Tel: 01903 737756
Email: planning@arun.gov.uk
www.arun.gov.uk/planning
Please ask for: Laura Mills
Email: laura.mills@arun.gov.uk
Telephone: 01903737794
Our Ref: EP/55/26/HH
Your Ref:
Date: 5th June 2026

Application for Planning Permission for Works or Extension to a Dwelling

Development: Replacement of first floor rear glazing.
Location: Vista Point 21 Tamarisk Way East Preston BN16 2TE

DRAWING No.
2105 3SC03.5

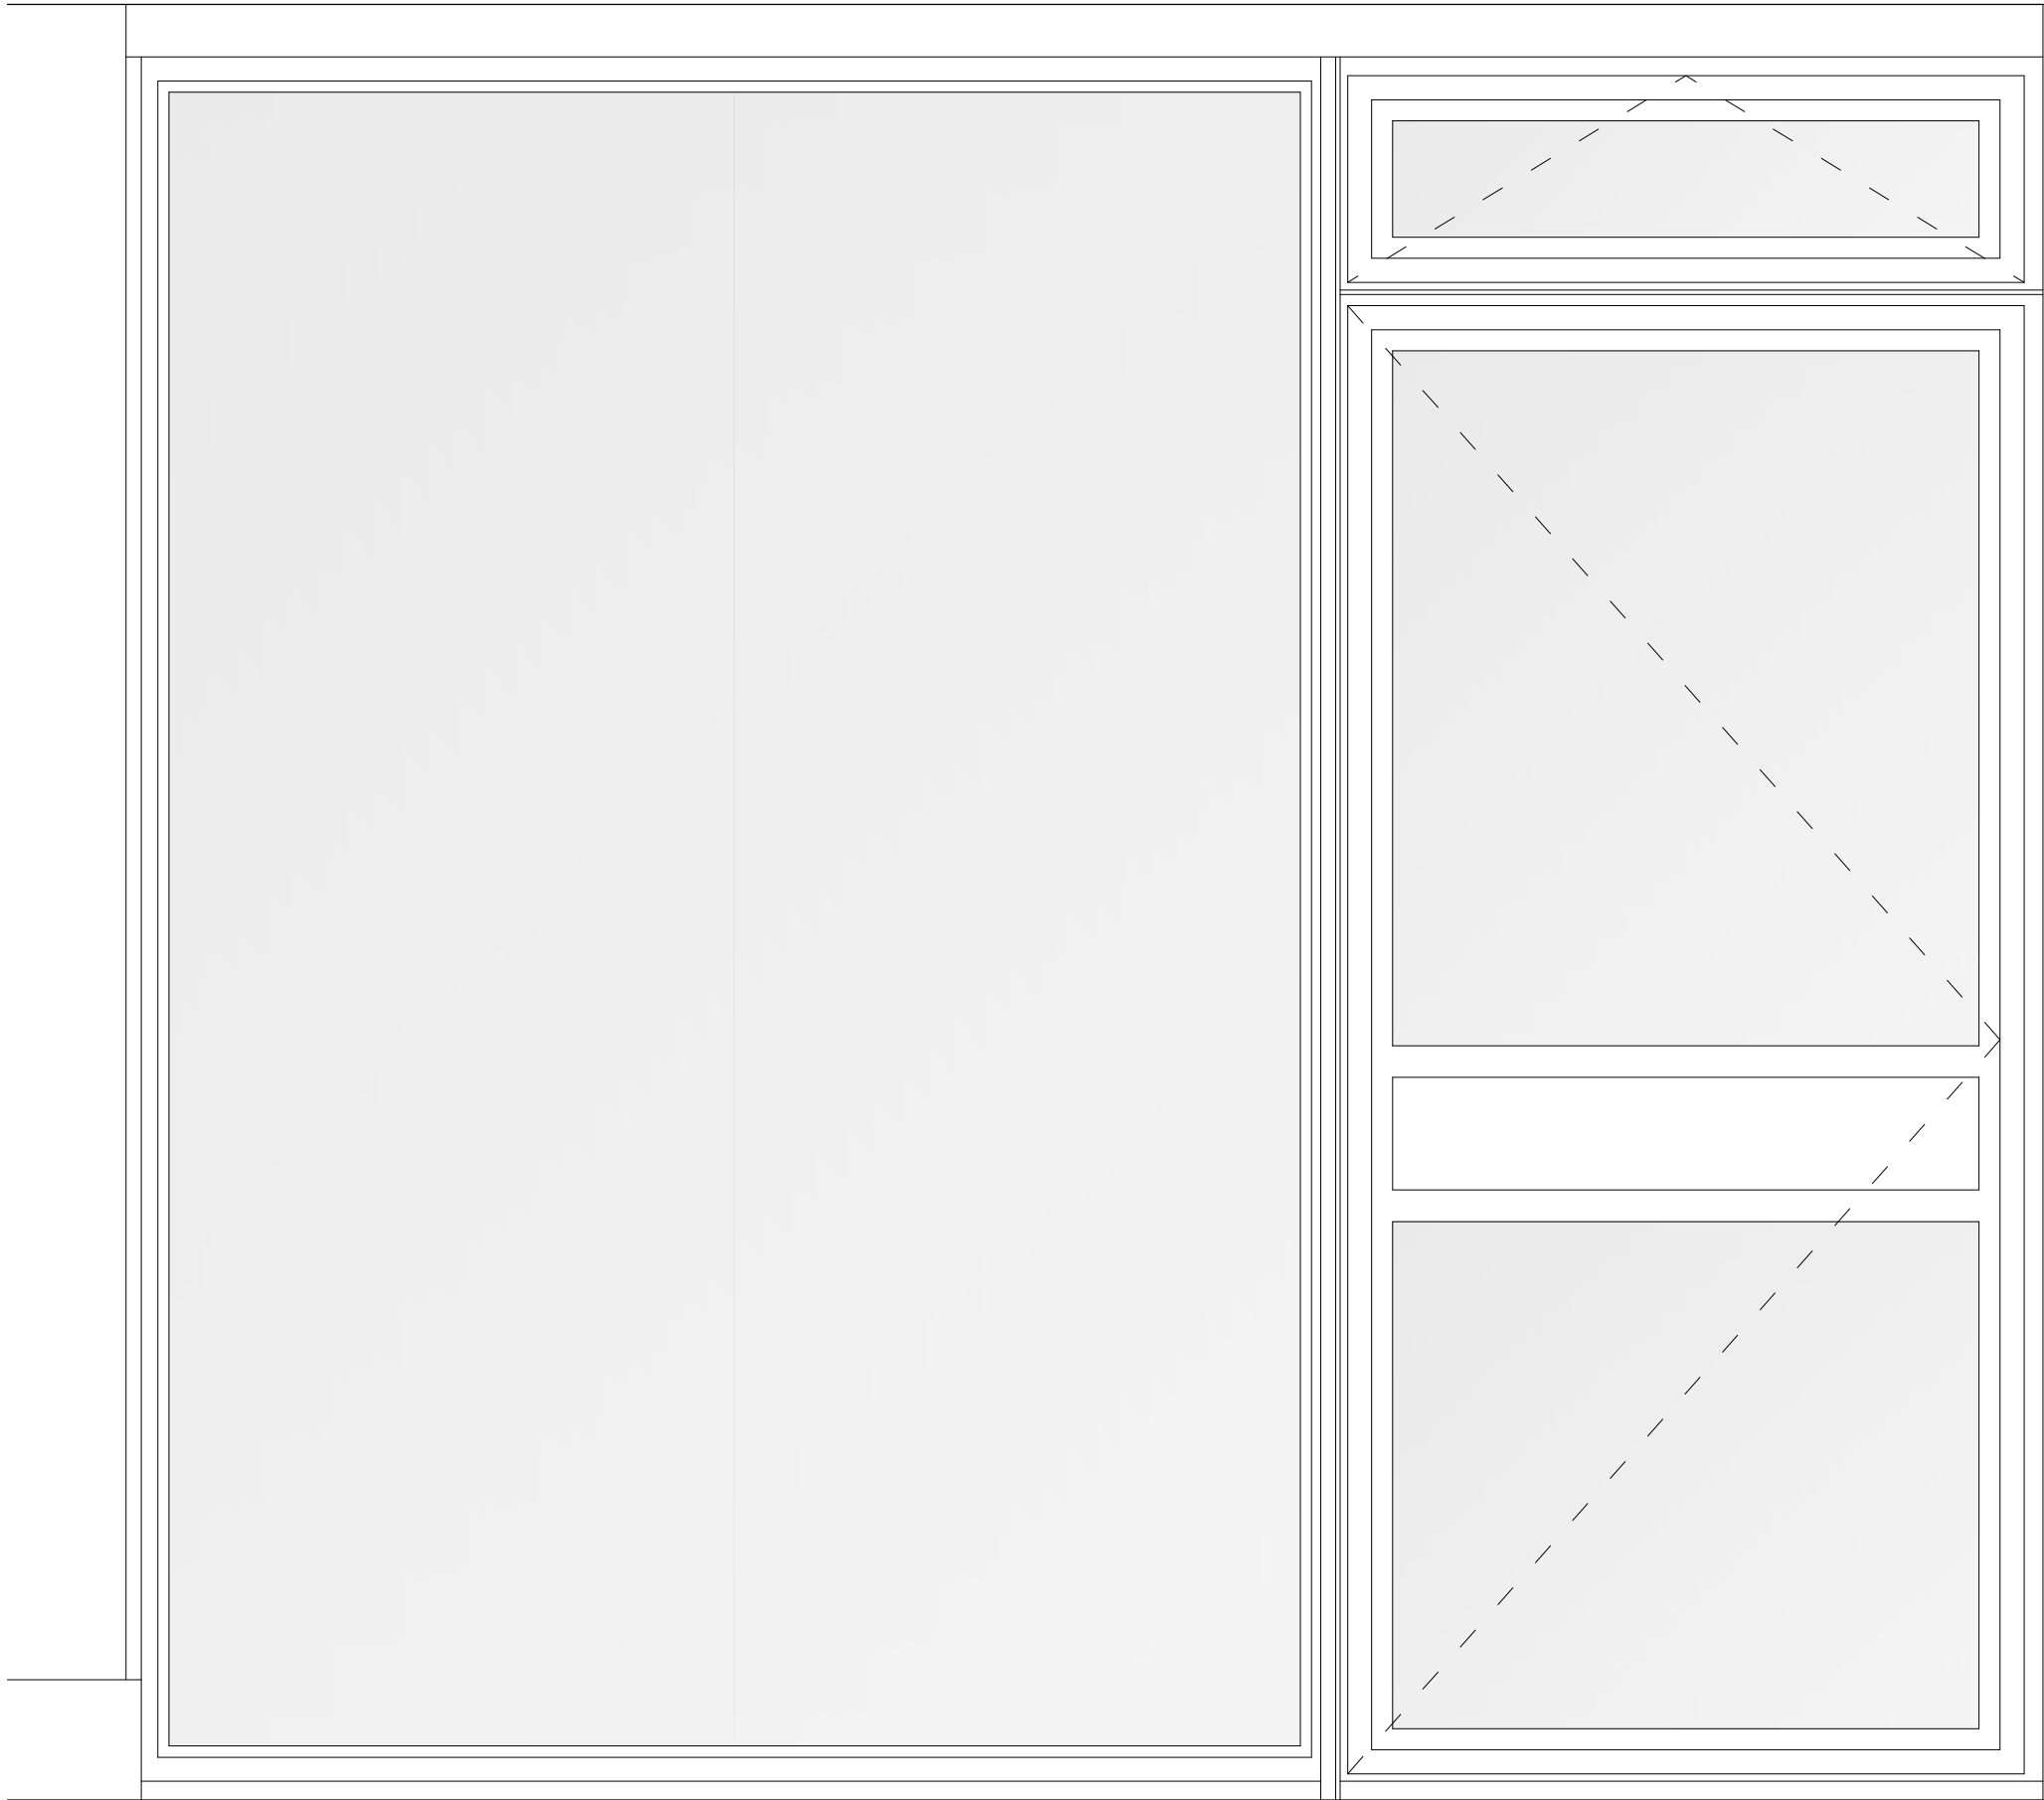
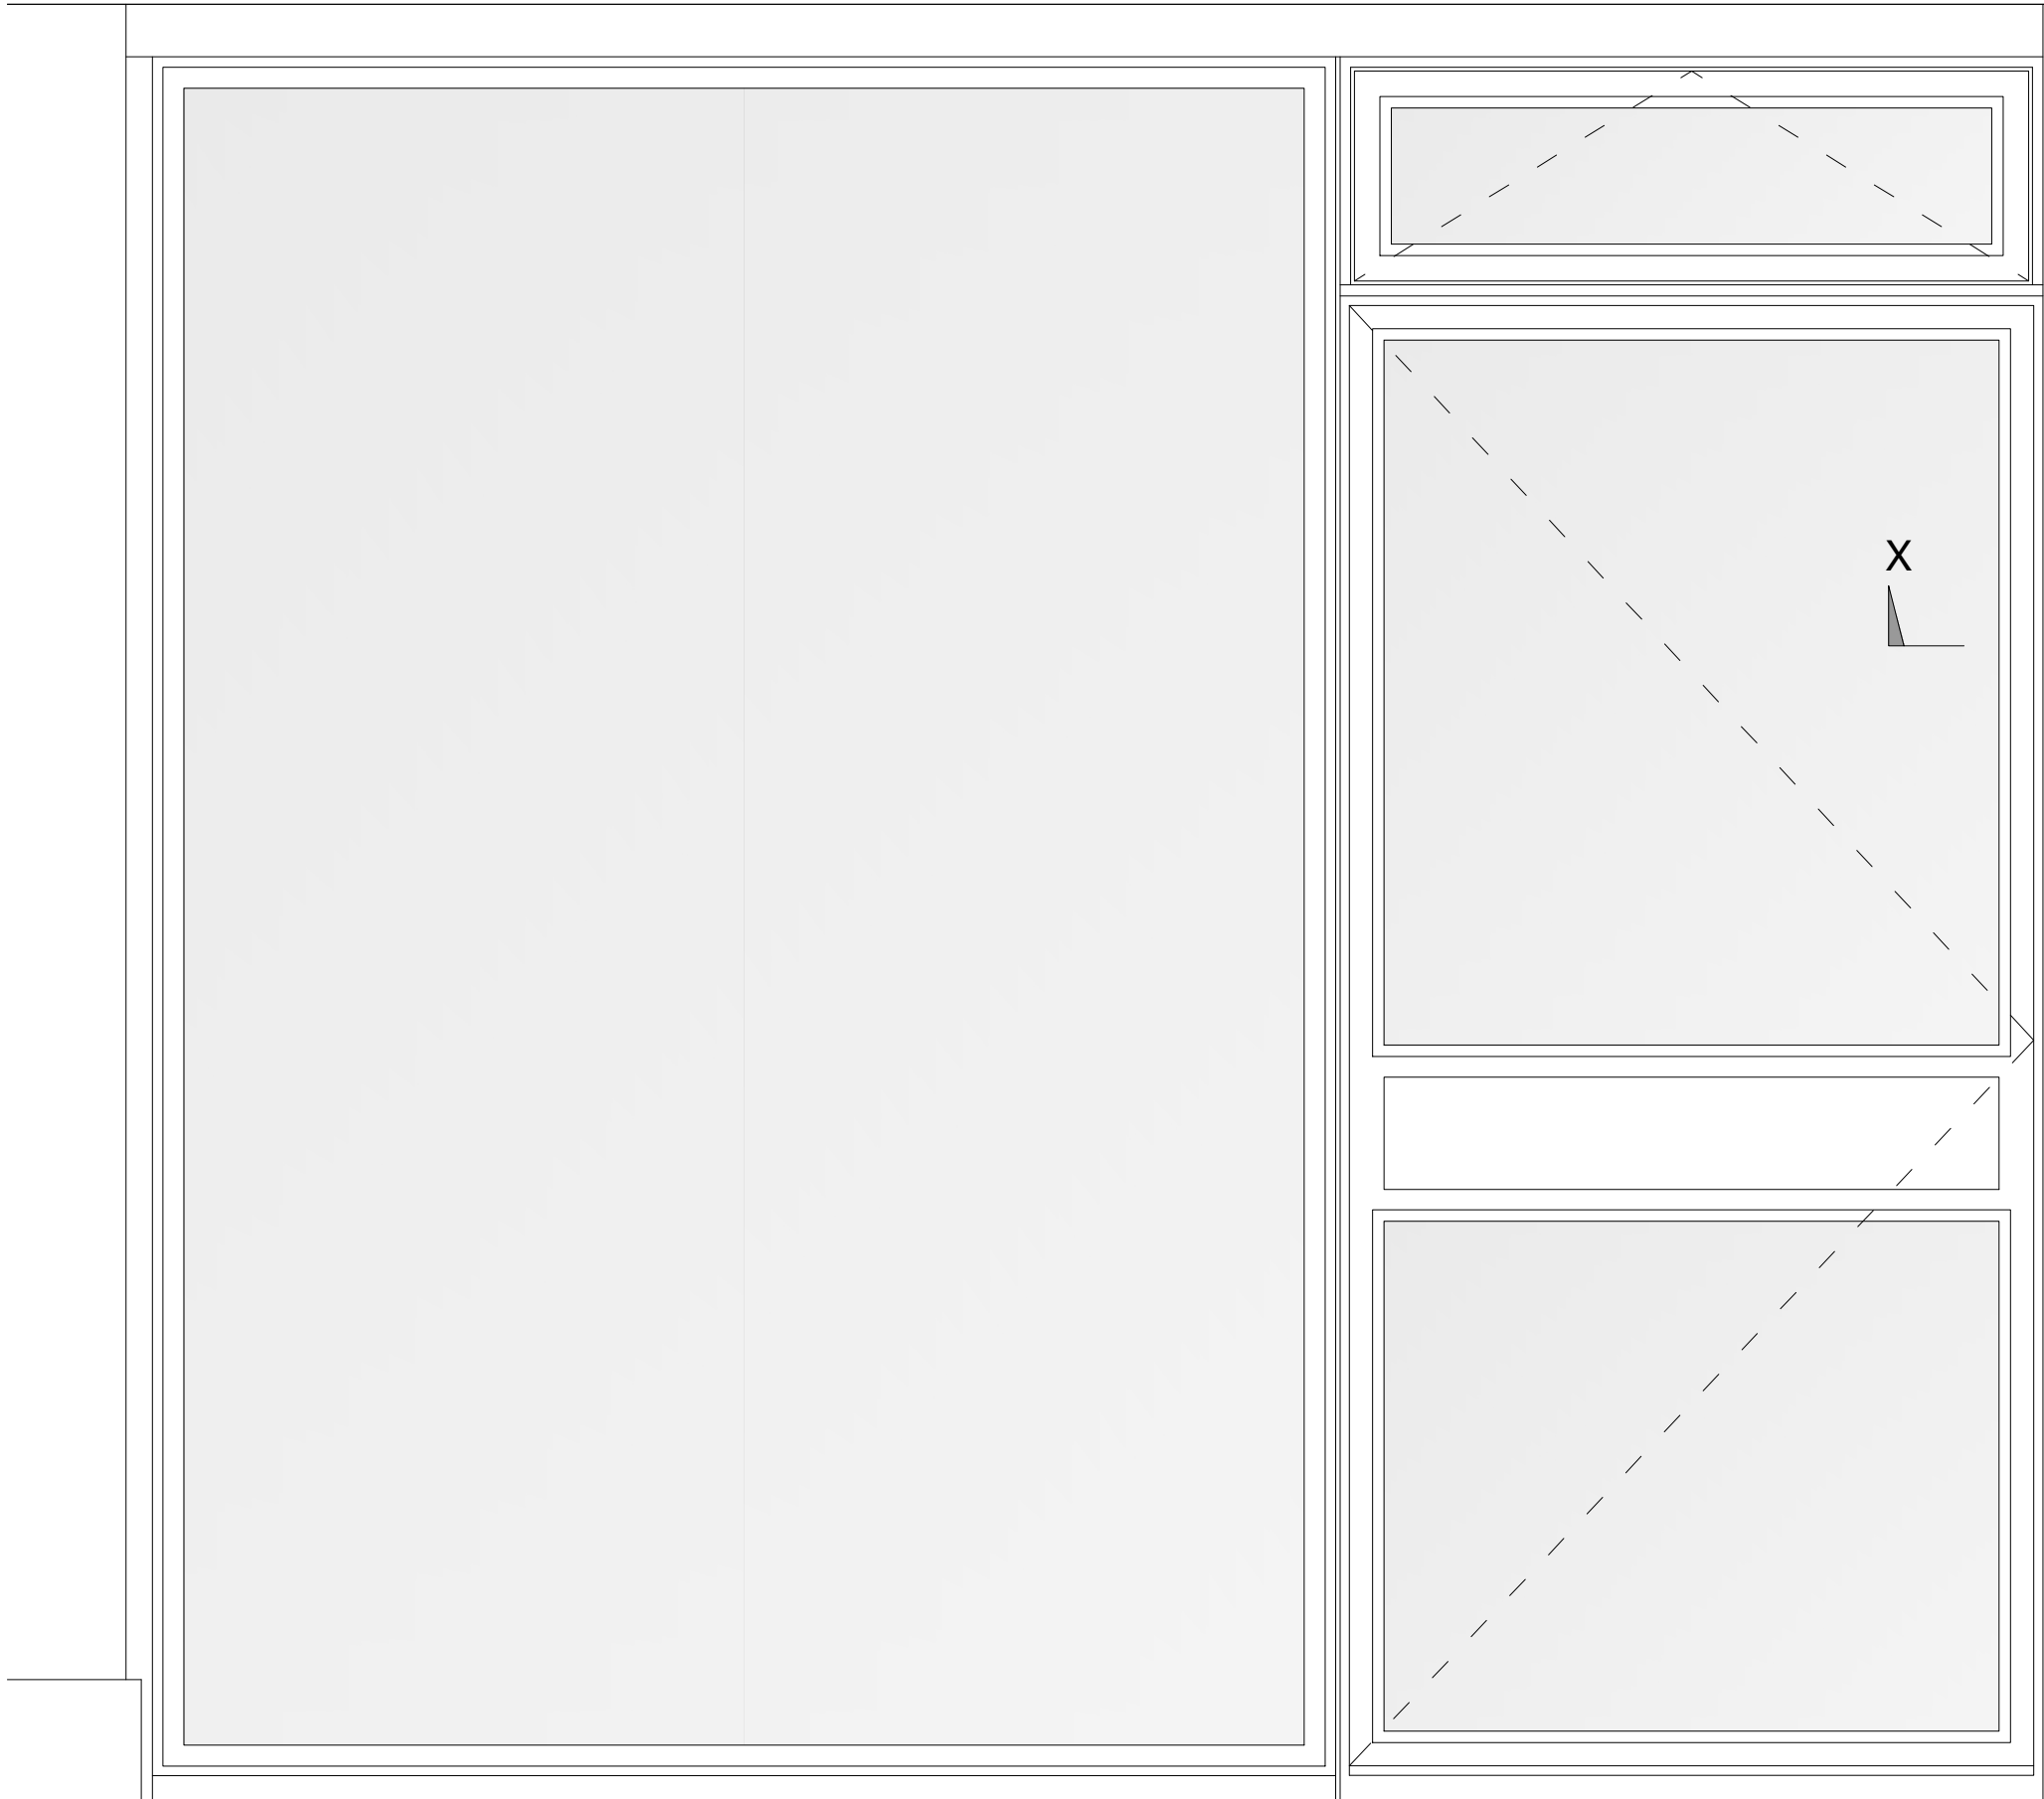
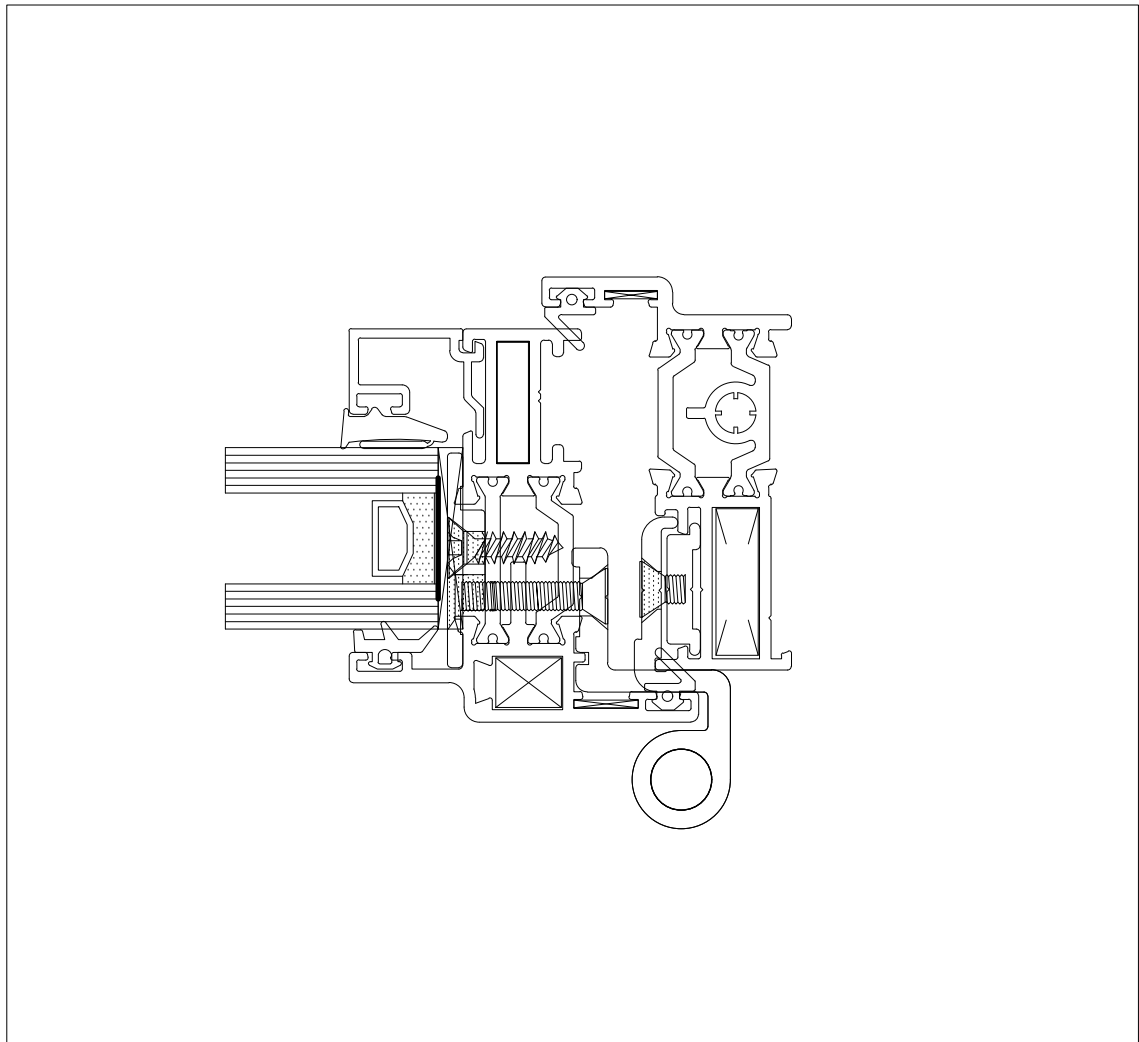
The scale bar does not scale at 1:10 and the plans should be provided to a scale of not less than 1:20.
